CITY OF ALBUQUERQUE

August 17, 2006

Re: Manzano Mesa Subdivision – Tract H1 of Manzano Mesa
Engineer's Stamp dated 8-8-06 (L21/D62)

## MANZANO MESA SUBDIVISION GSL PROPERTIES CONCEPTUAL GRADING AND DRAINAGE PLAN

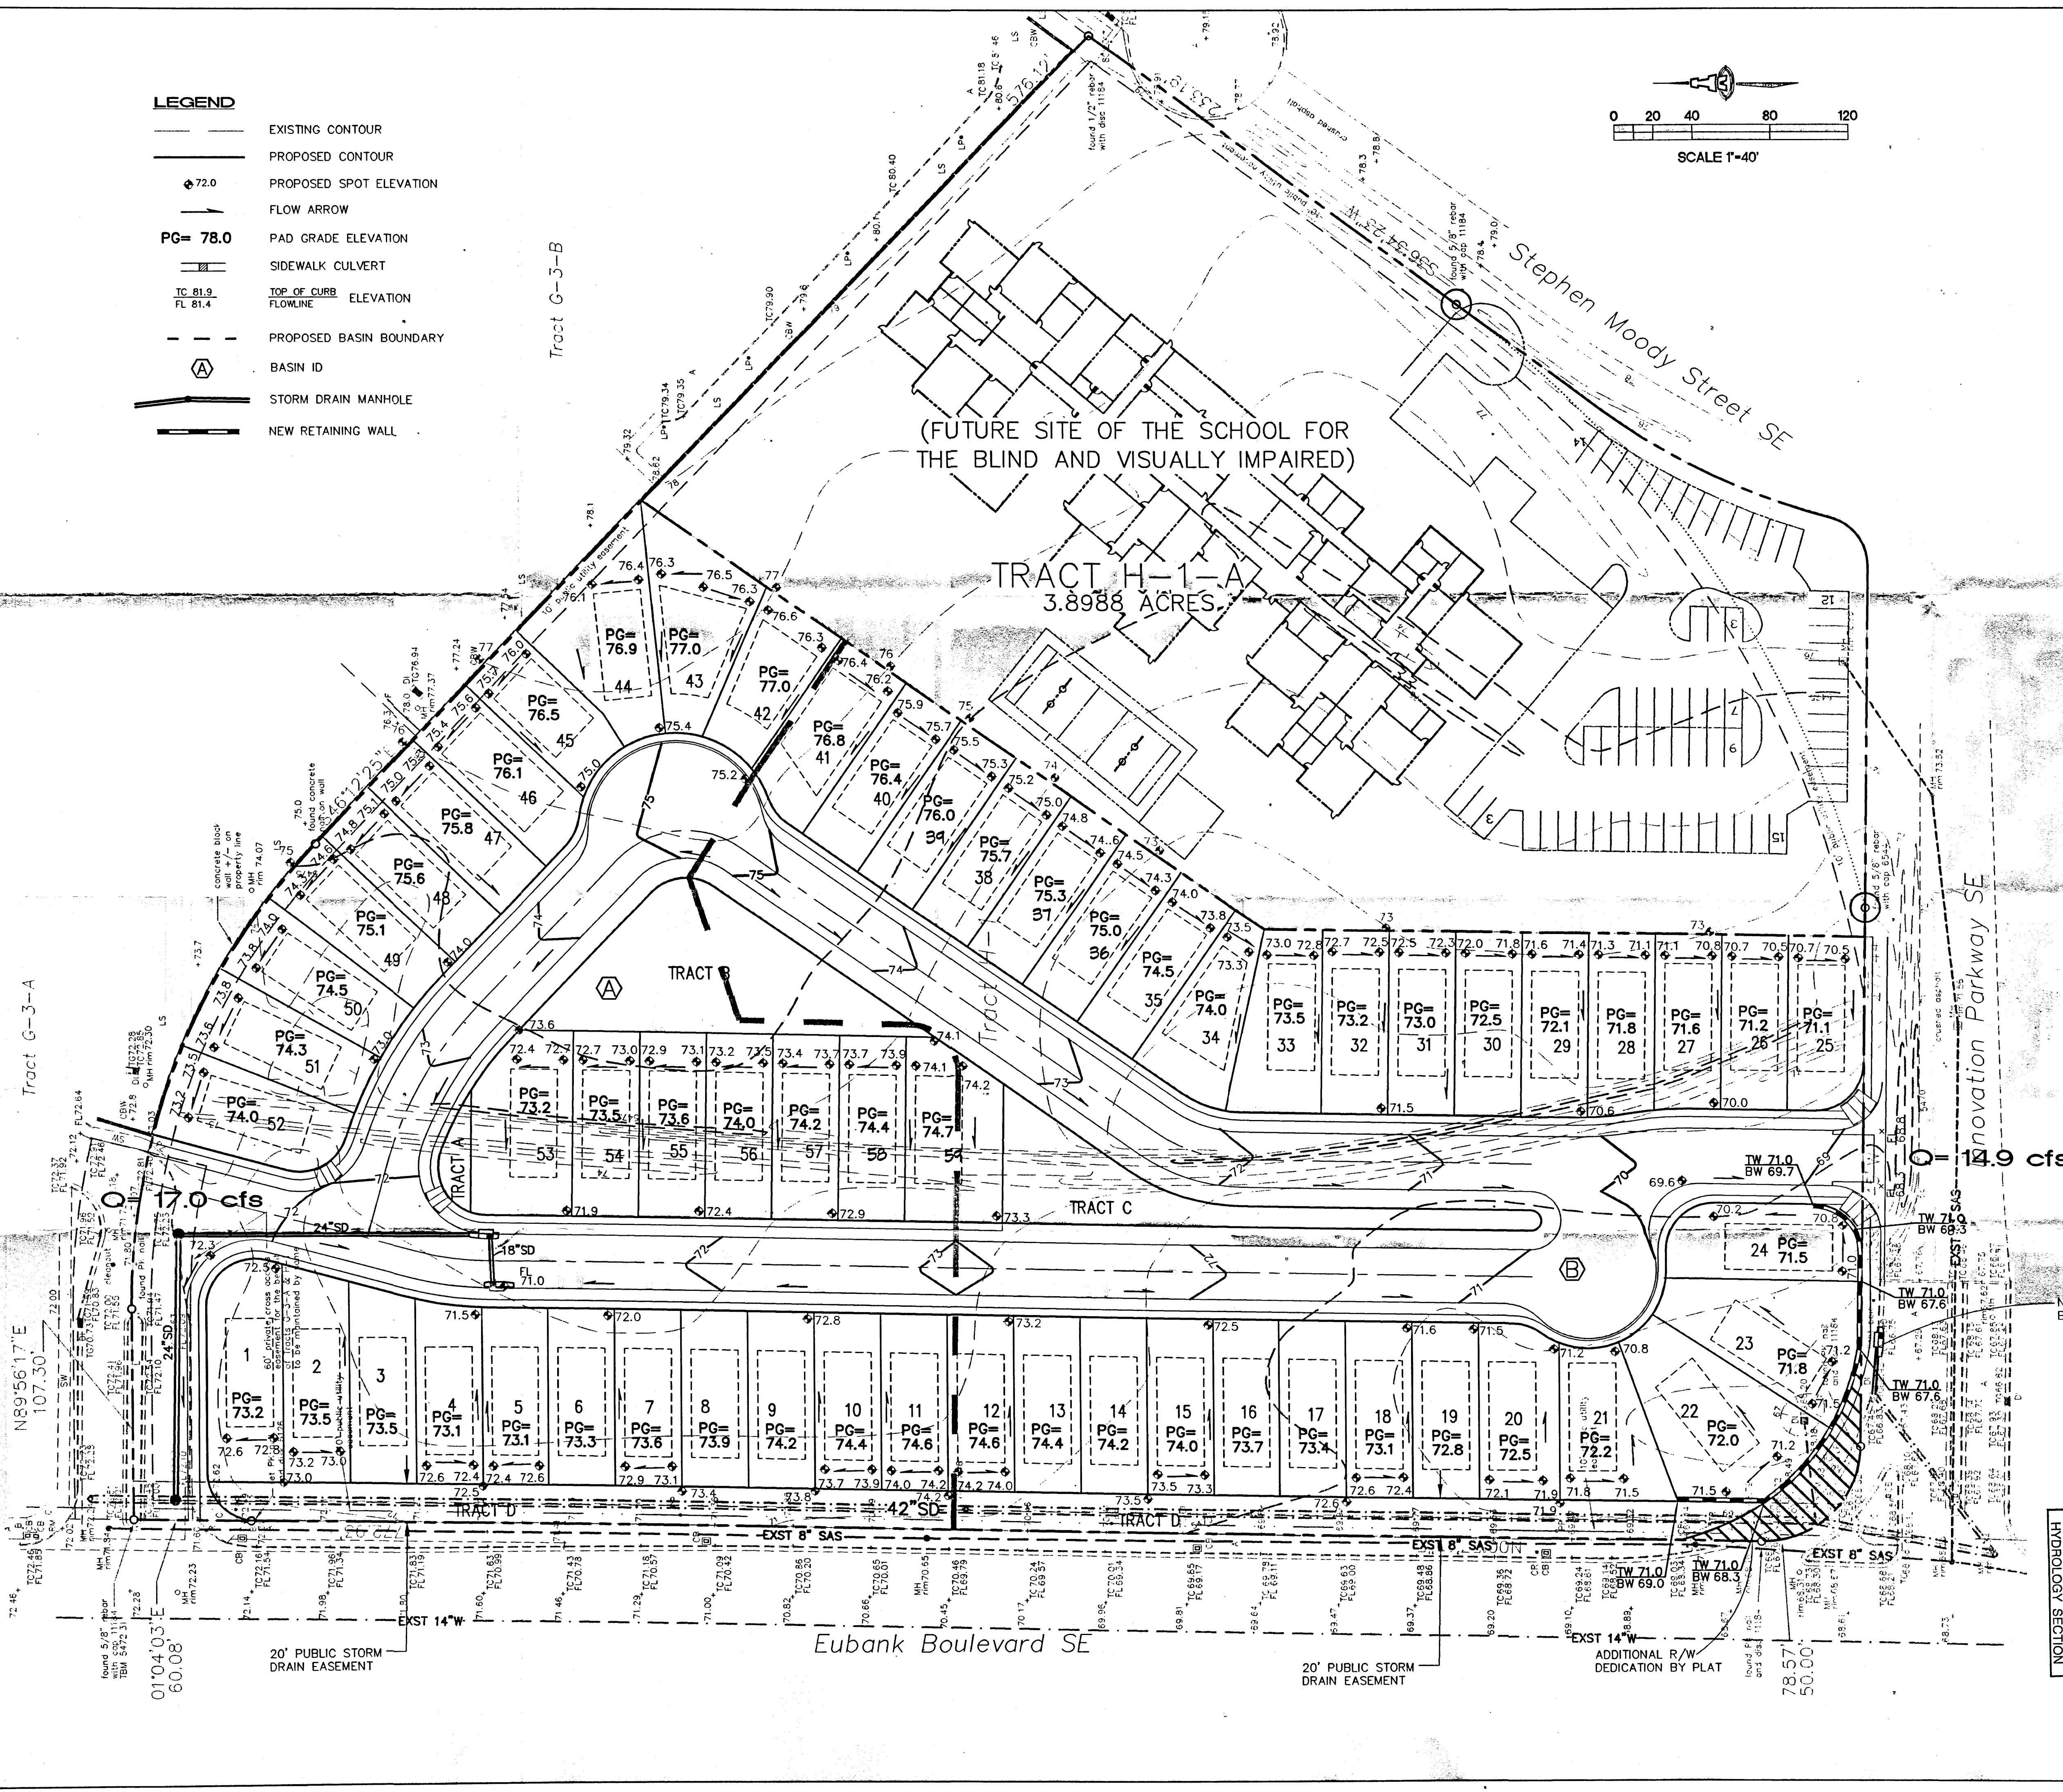
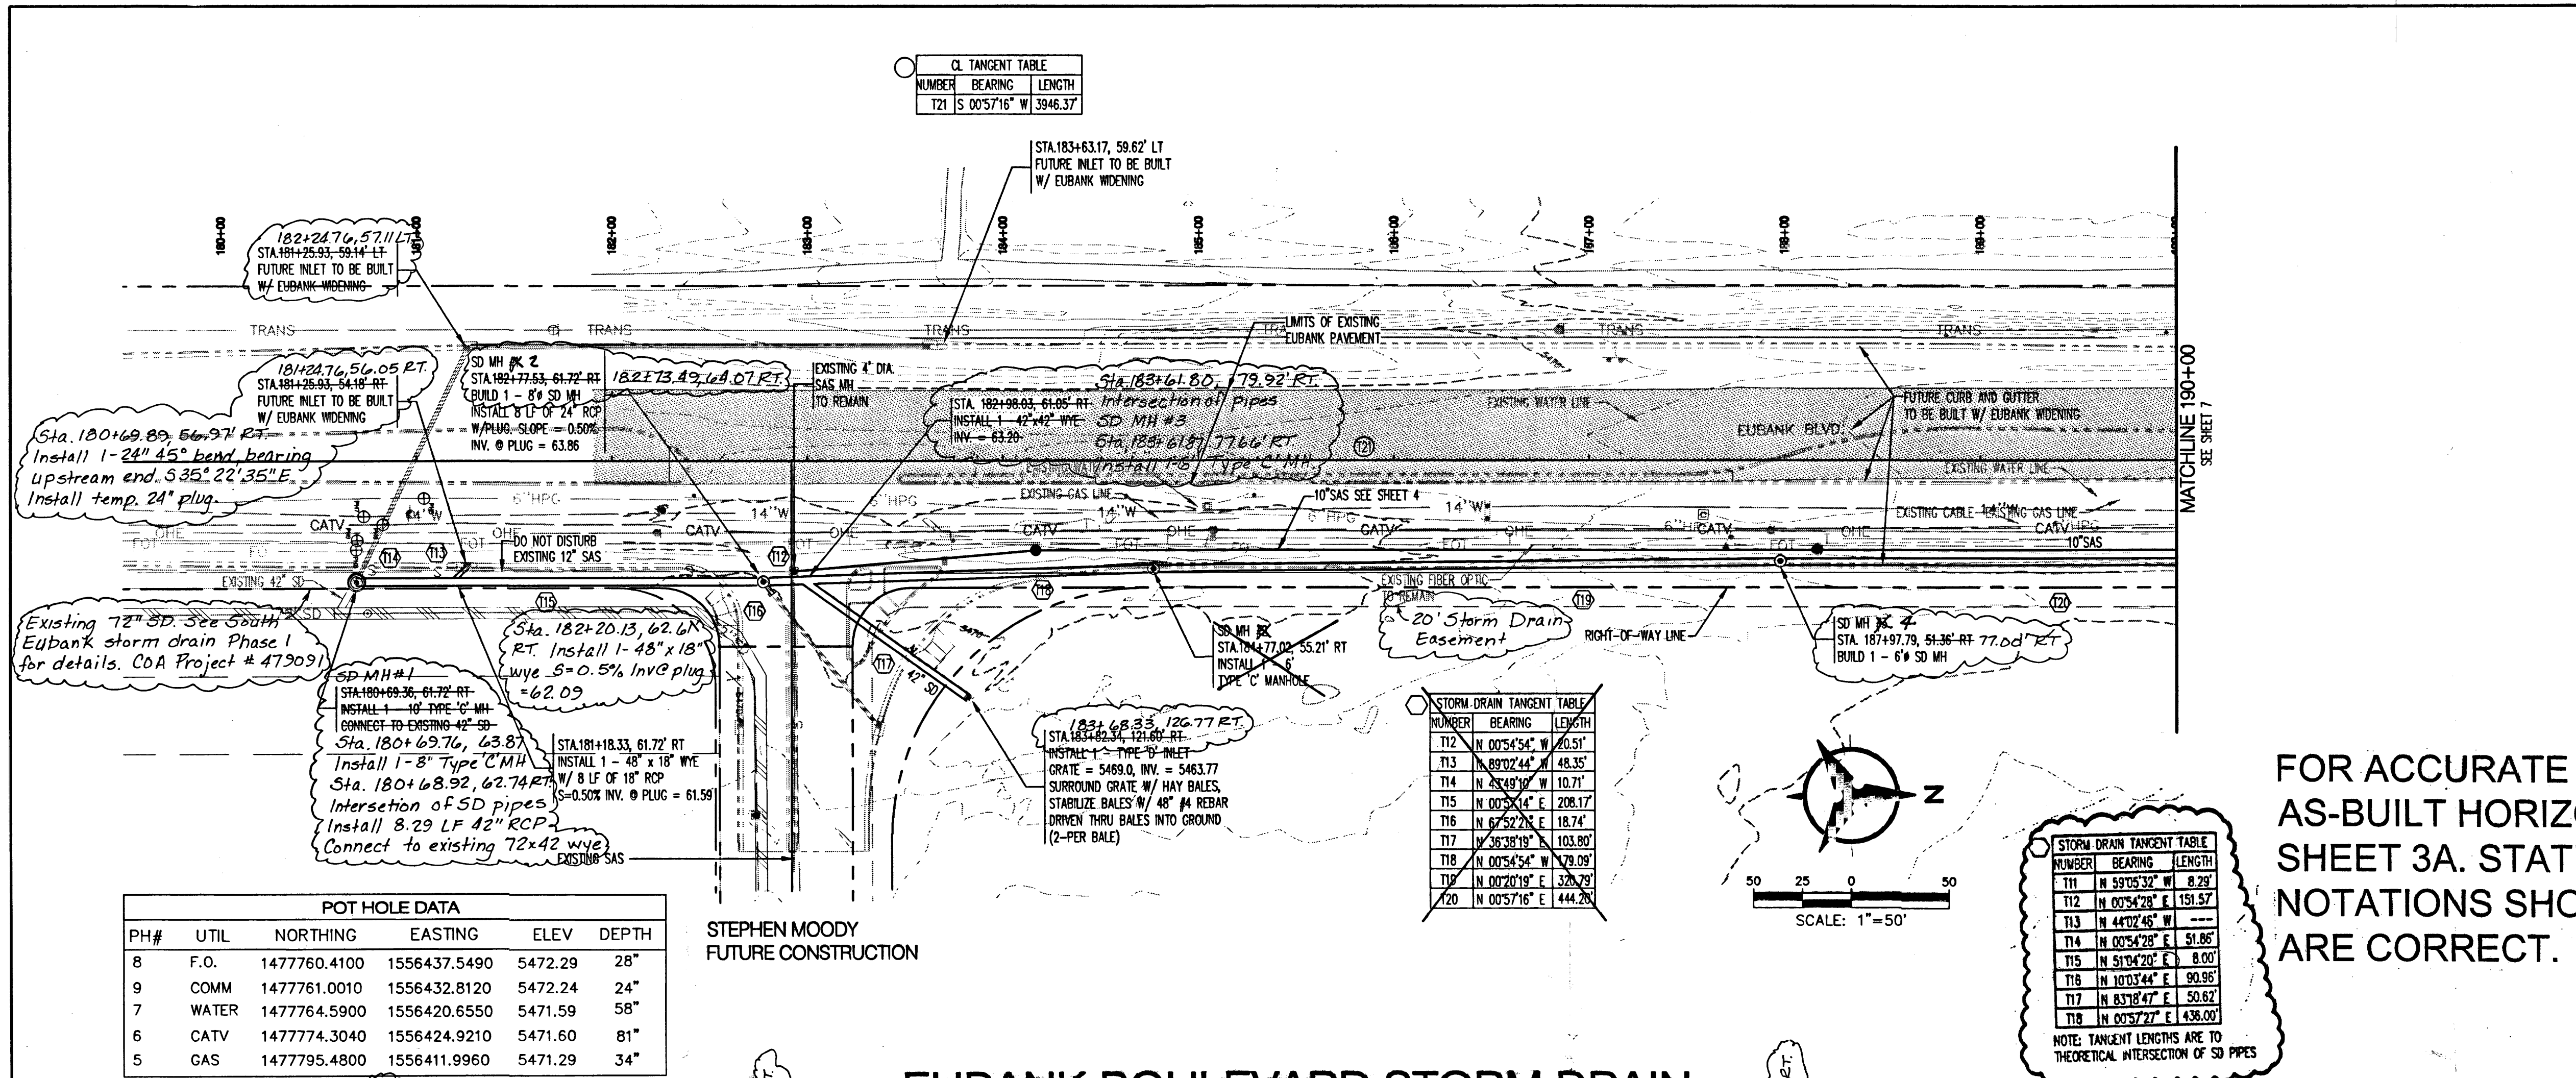
Based upon the information provided in your submittal received on August 9, 2006, the above referenced Site Development Plan for Subdivision is approved for action by the DRB. However, with your submittal to the DRB, the benchmark used for the design must be indicated and the narrative reference to the Eubank storm sewer must be revised from 48-inch to 42-inch in conformance with the plan and record drawings.
